Application for a Non-Material Amendment Following a Grant of Planning Permission

Householder Application - Erection of single storey rear extension.

DC/23/04390

PROJECT 6 LONDON ROAD, CAPEL ST.MARY	REF. LR_ALT_04	REV. PA-2
DRAWING ELEVATIONS AS PROPOSED	SCALE 1:50 @ A2	DATE MAY 2023

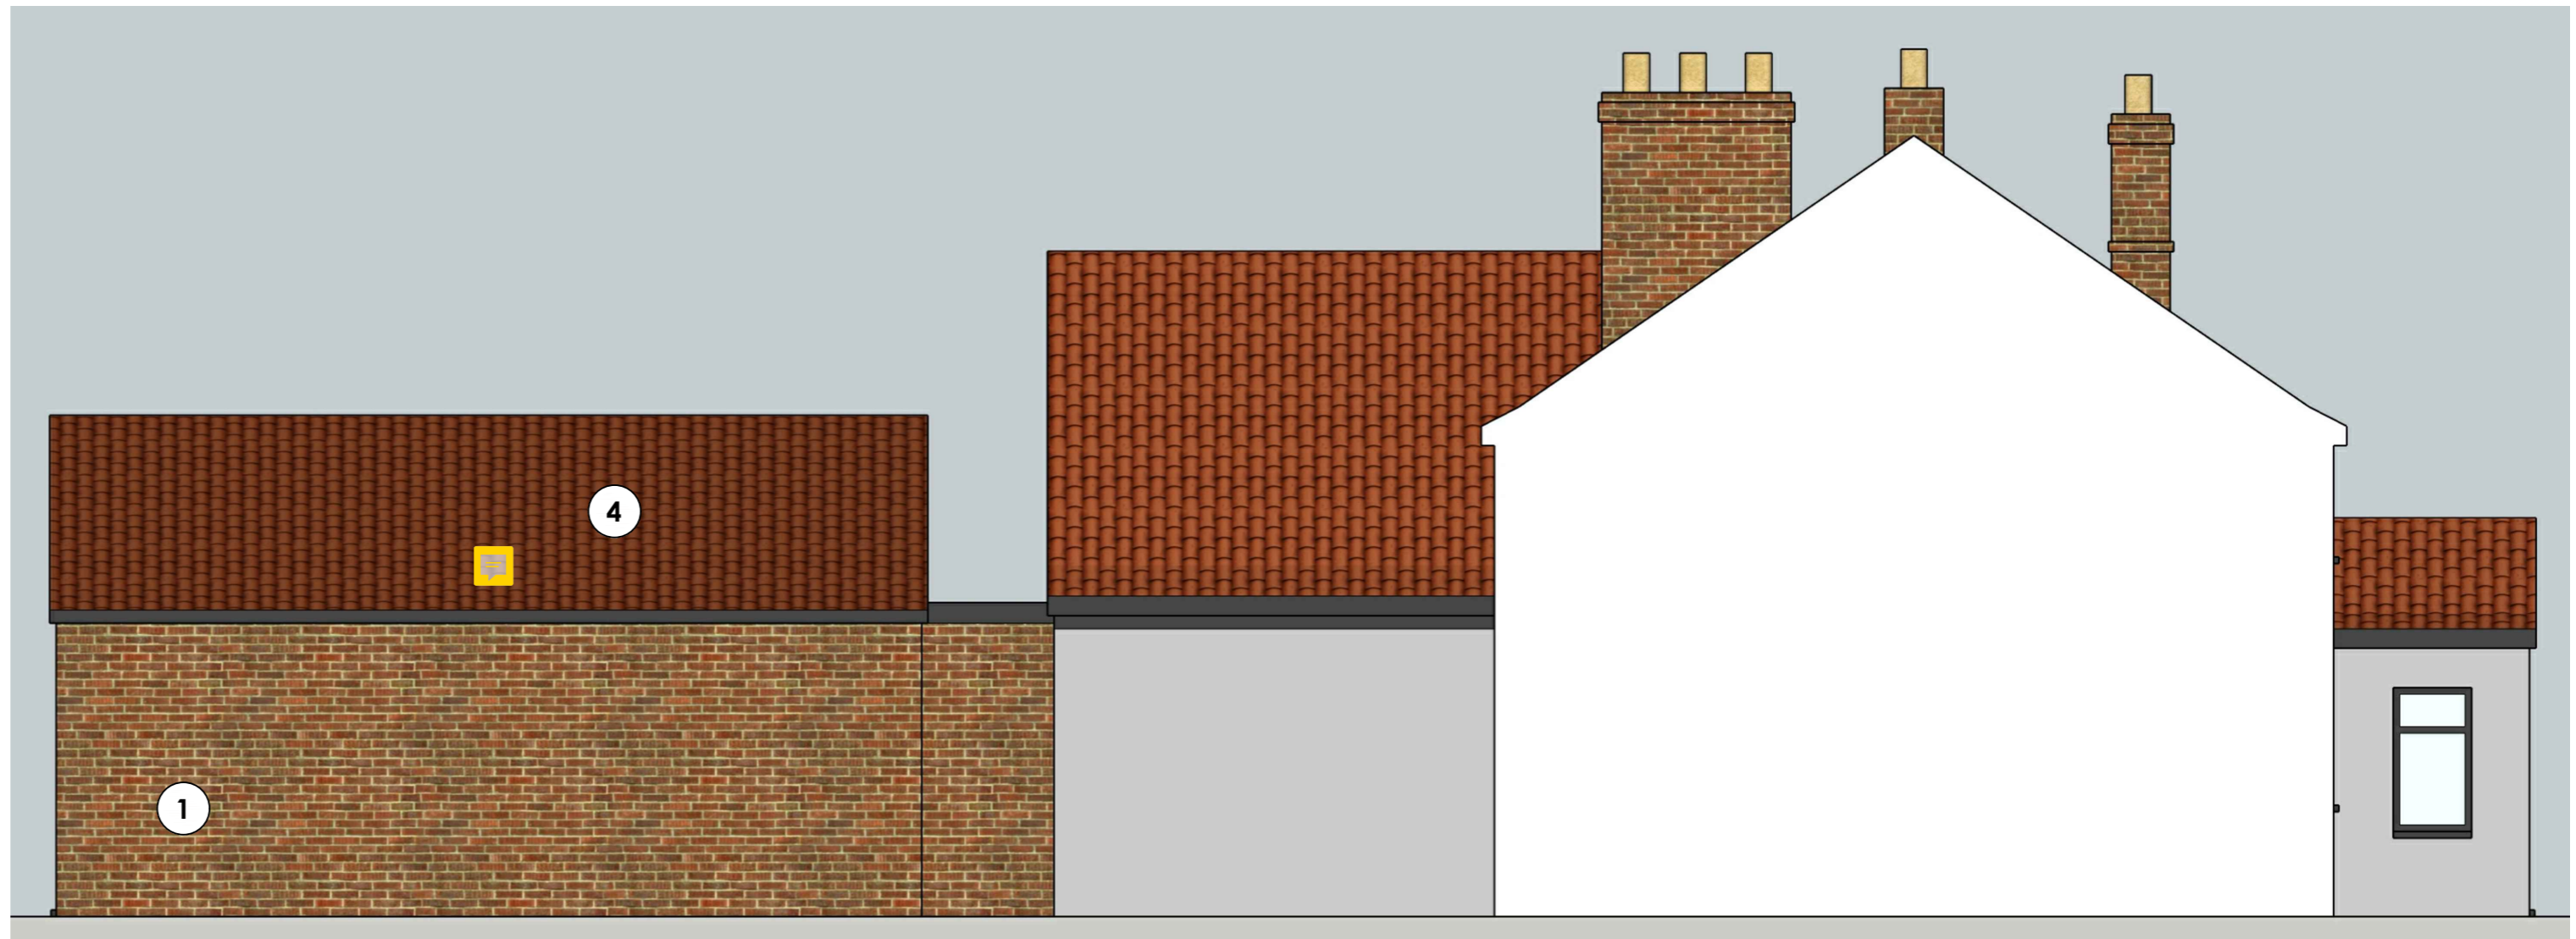
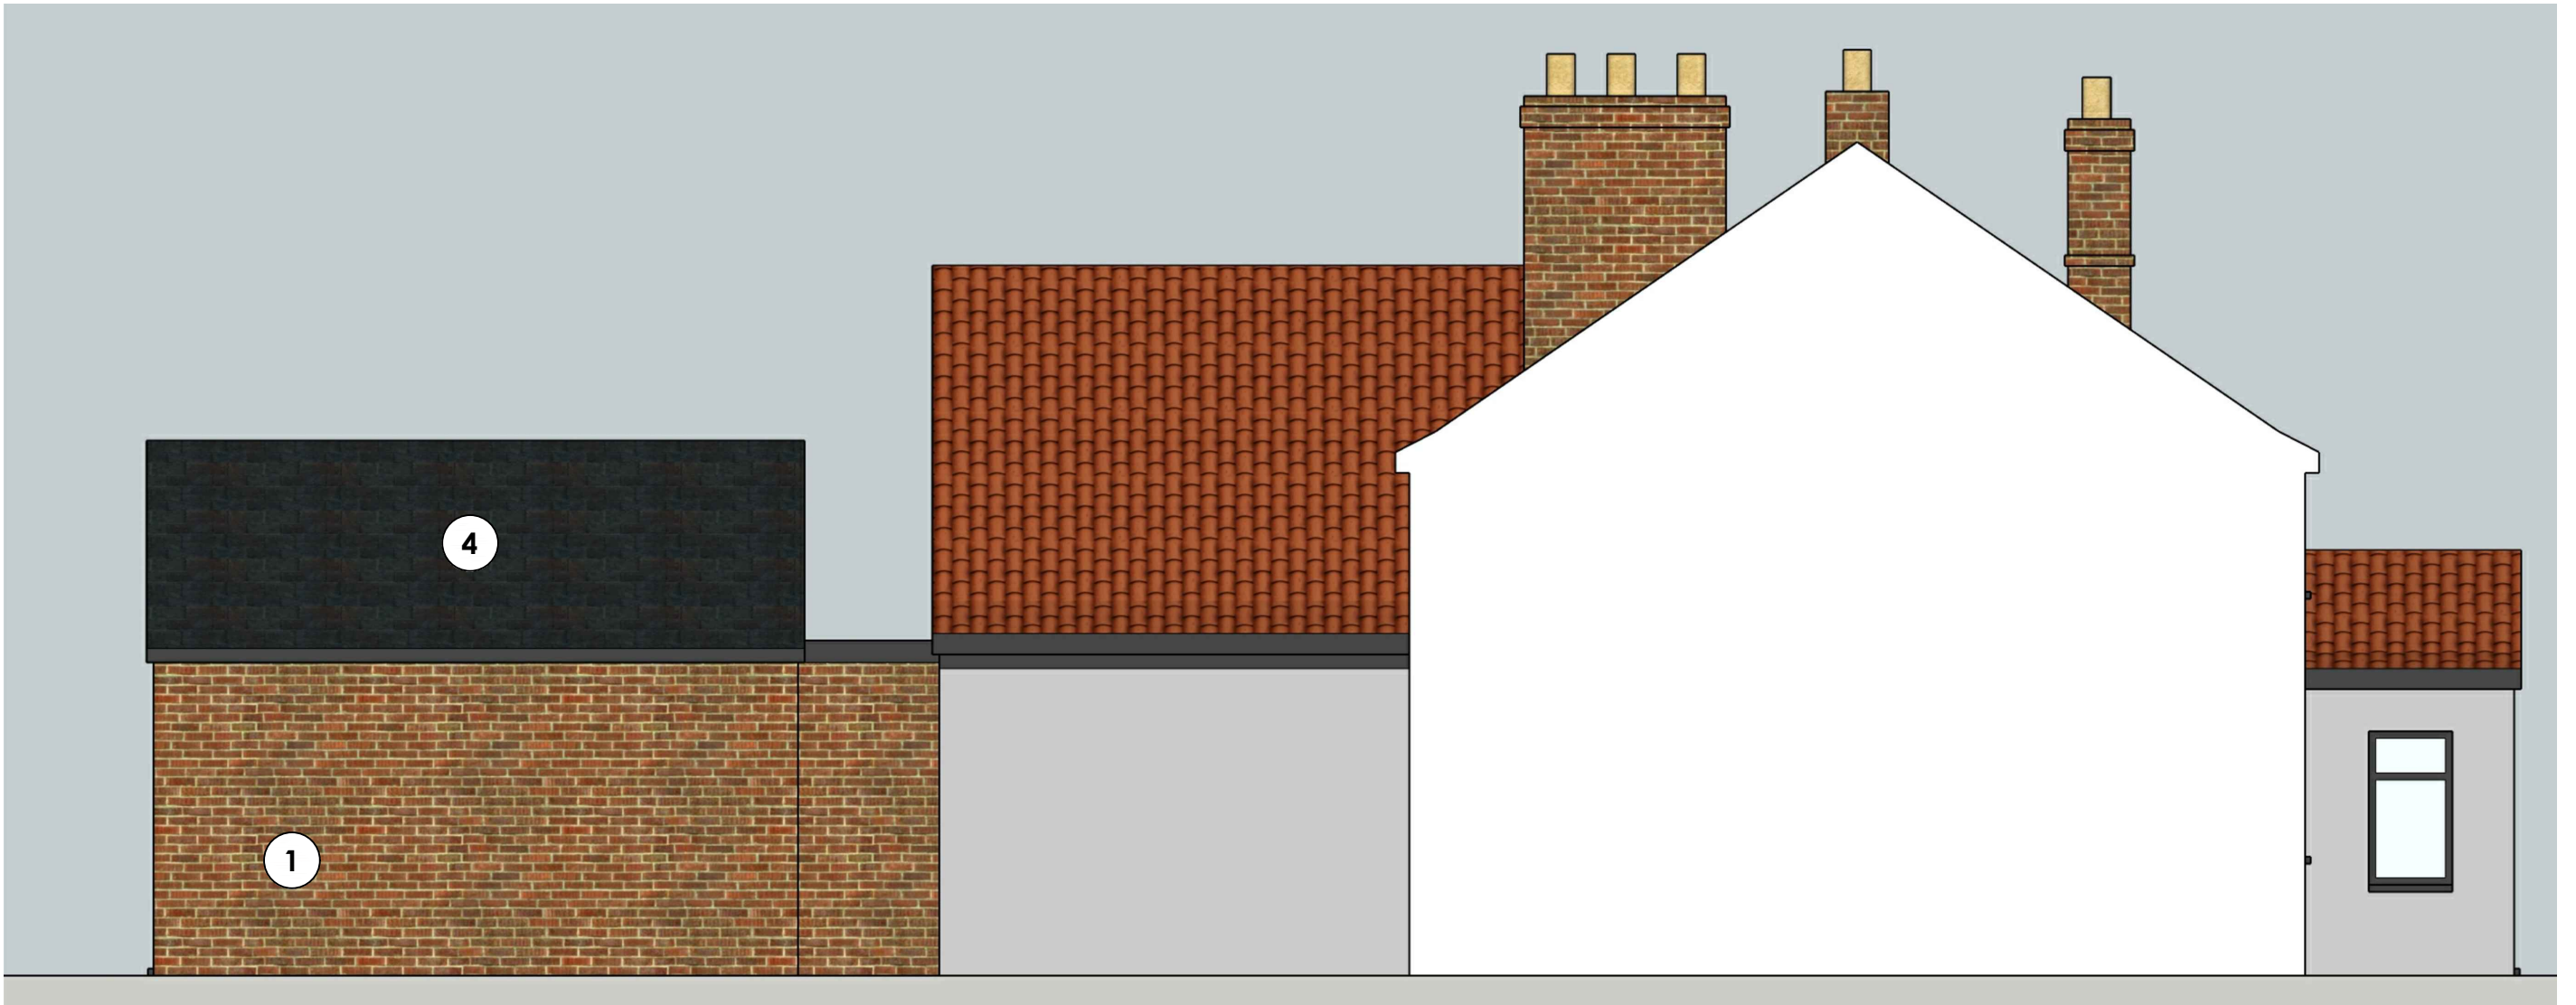
1. Depth of Rear Extension reduced by 2m (from 8.15m to 6.15m)
2. Roof Covering revised from Clay Pantiles to Natural Slates
